Re: Salvation Army Dining Hall - Rooftop Units

Subject: Salvation Army Dining Hall - Rooftop Units

NORTHWEST ELEVATION
 0 4'-0" SCALE: 1/4" = 1'-0"

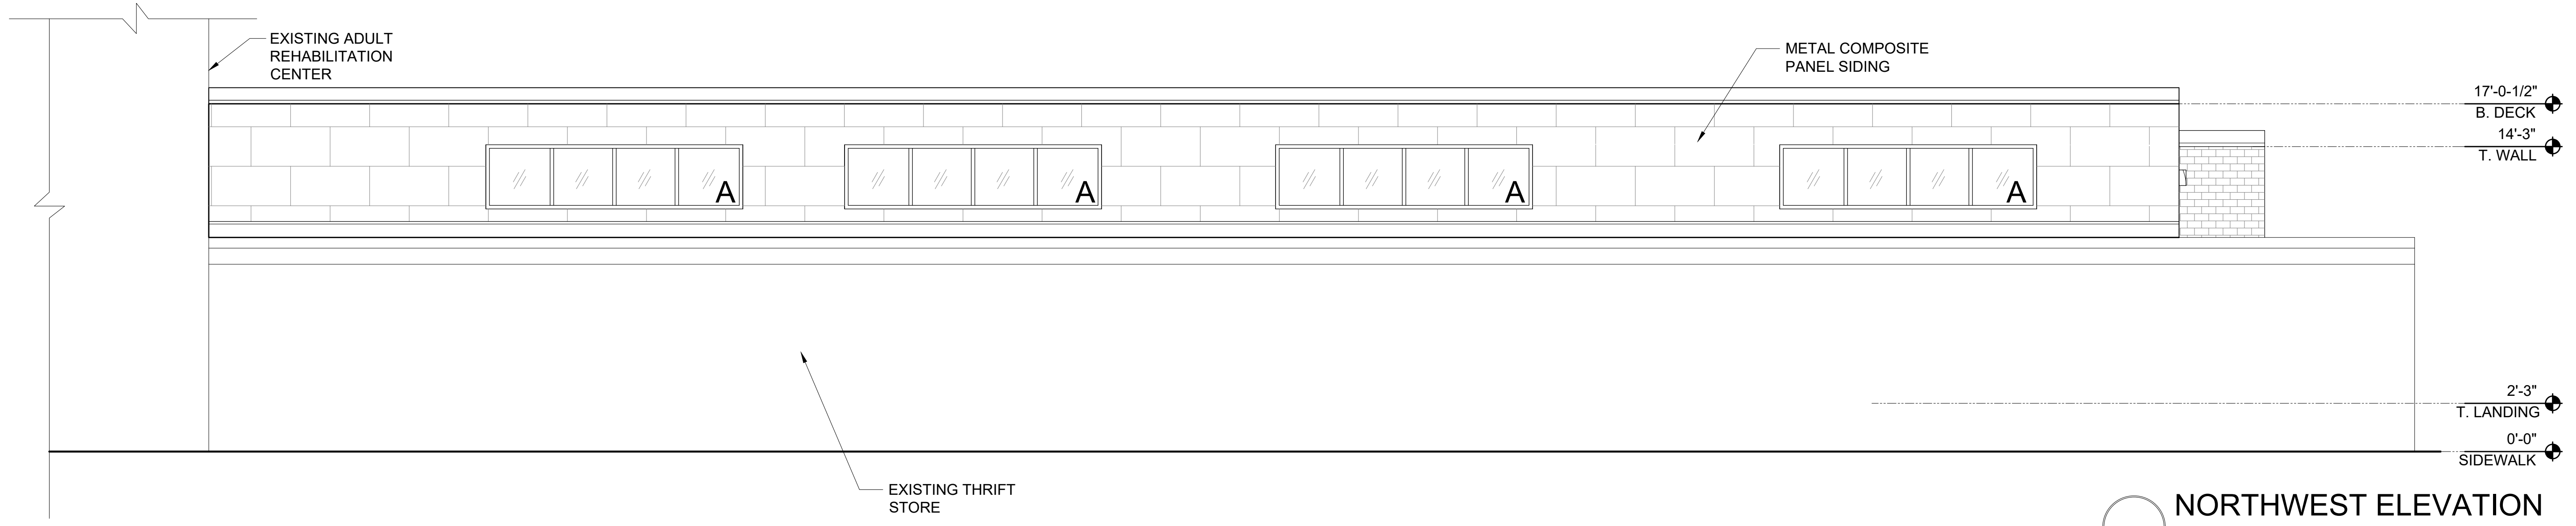
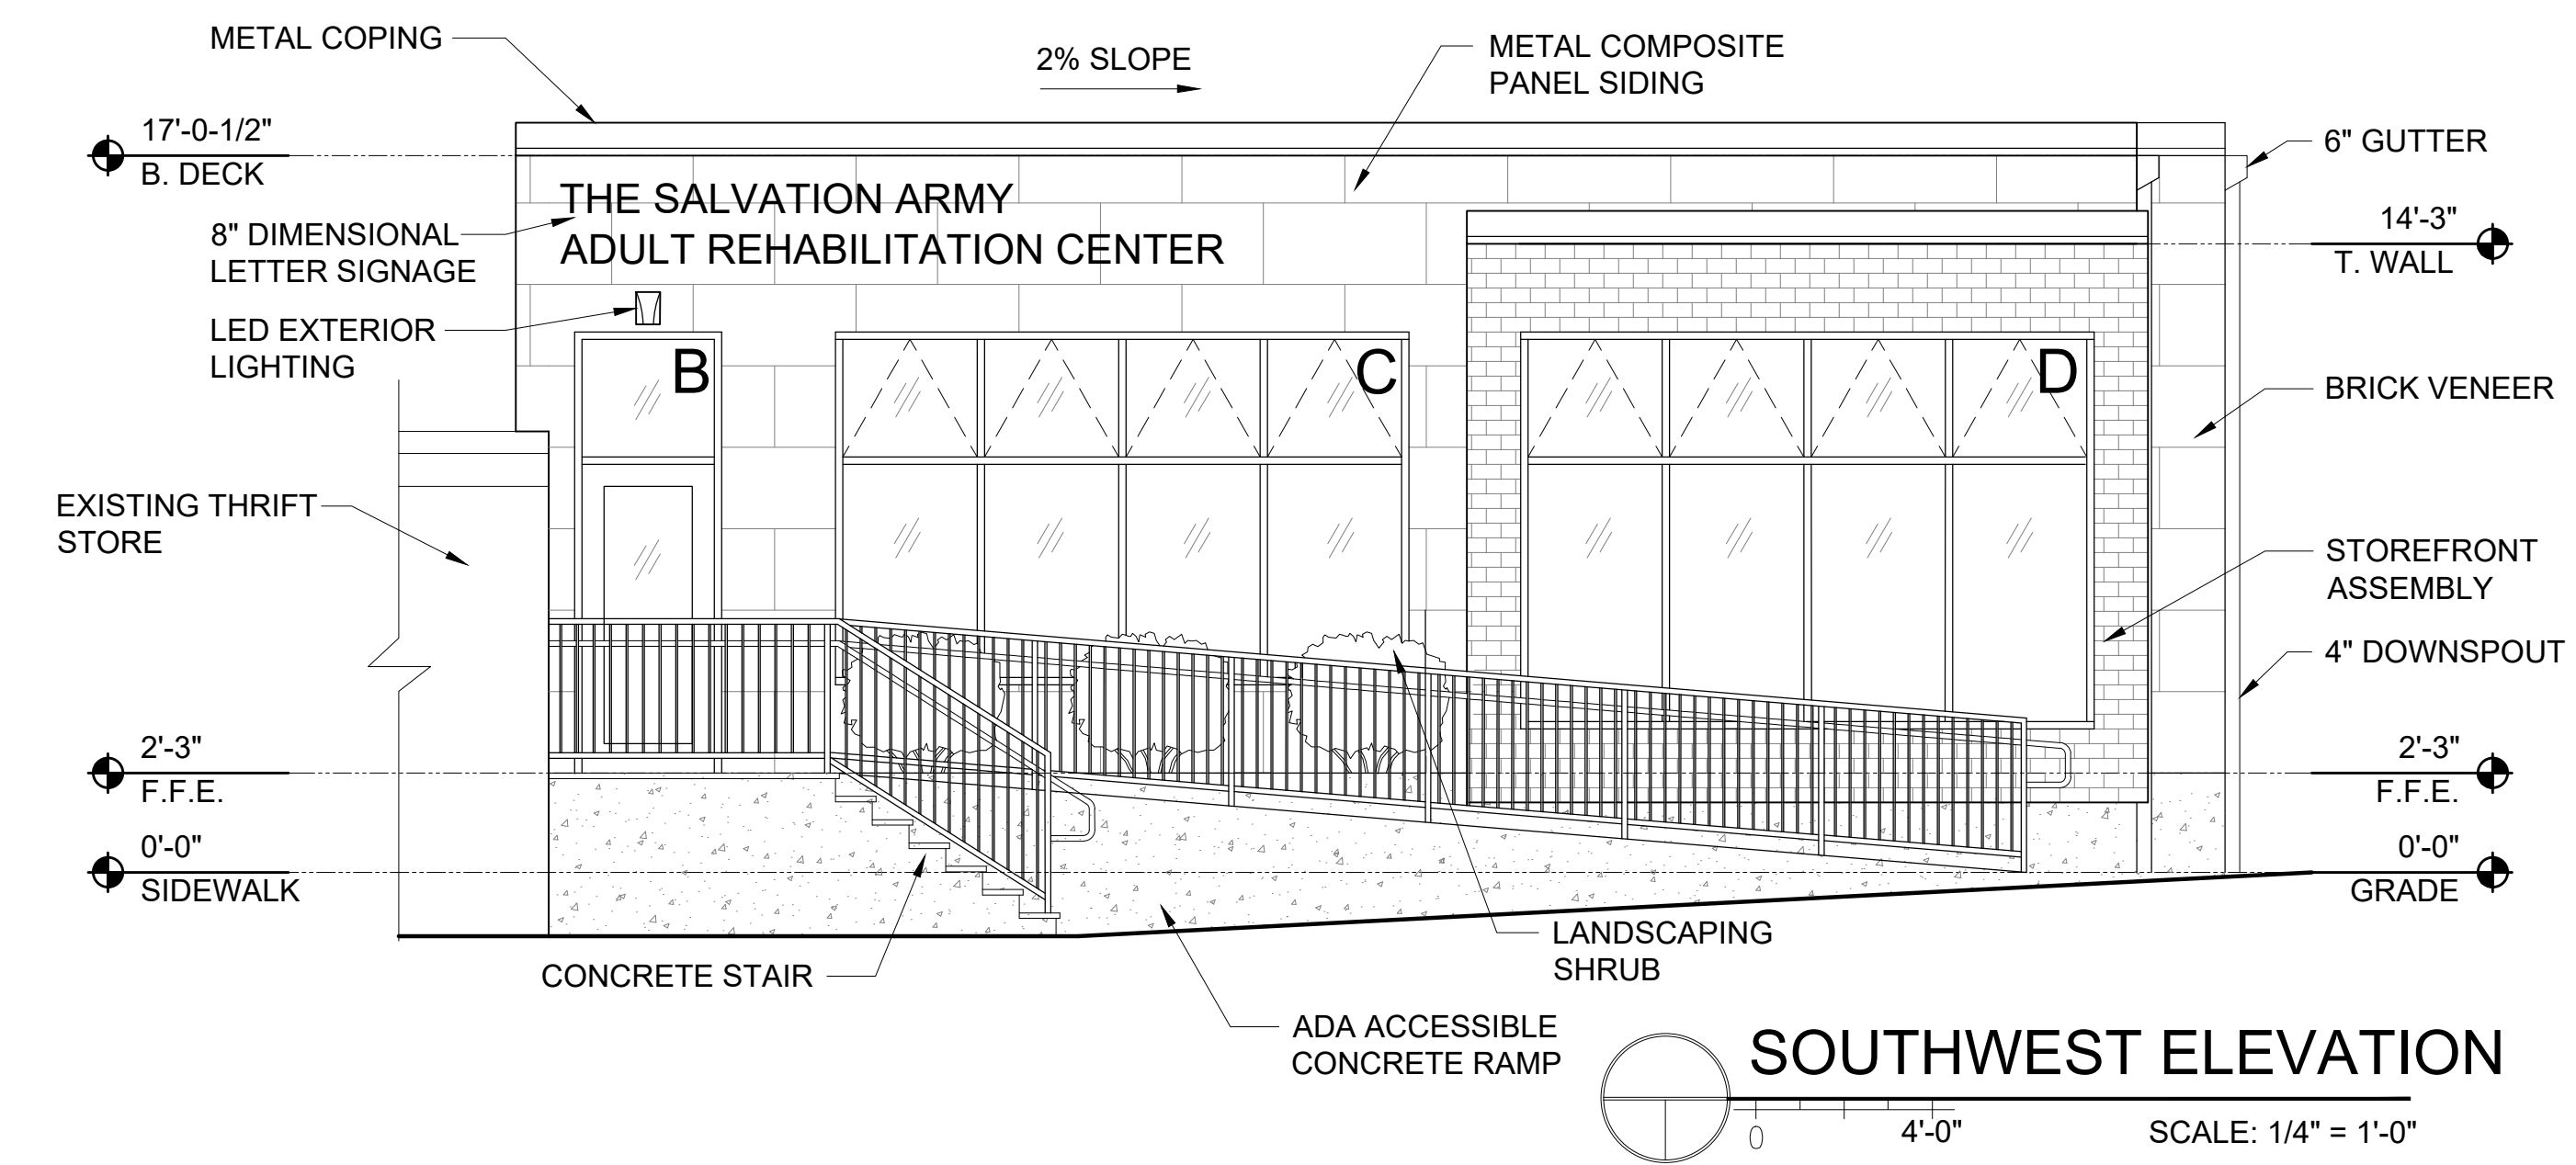
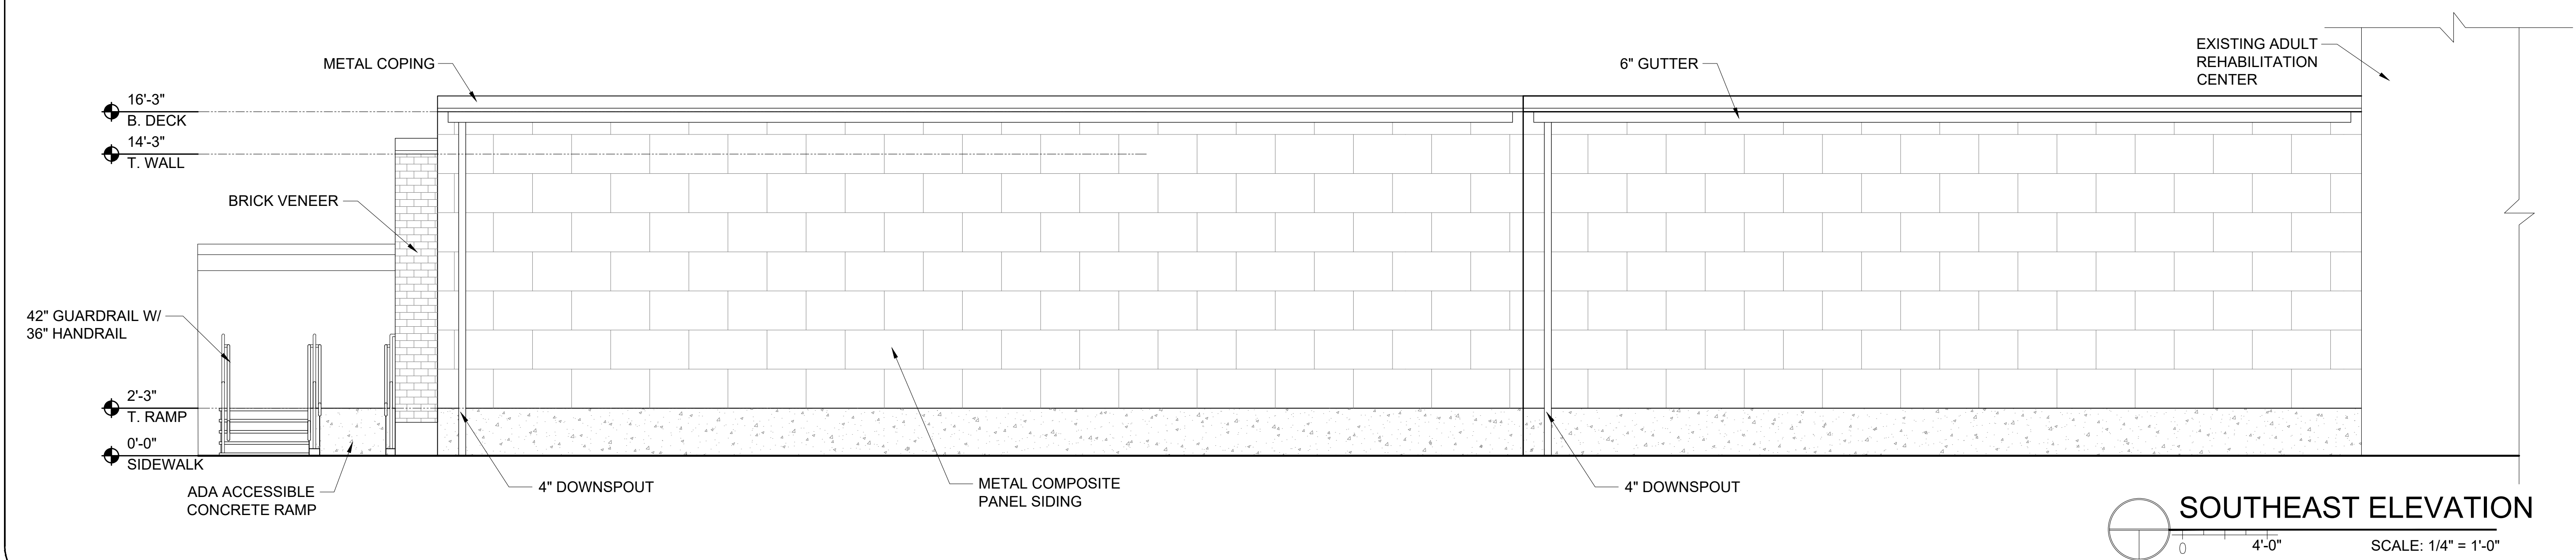
I have discussed it with the Urban Design Reviewer Caitlin and can confirm that we agree that the roof mounted units do not need screening- as long as they are located where they are shown in the video. If that changes we would like to review the question again.

We do not intend to install any screening of the rooftop units. I hope that this video helps you to see why. Our parapets and the locations of the units keeps them quite screened from view in most locations.
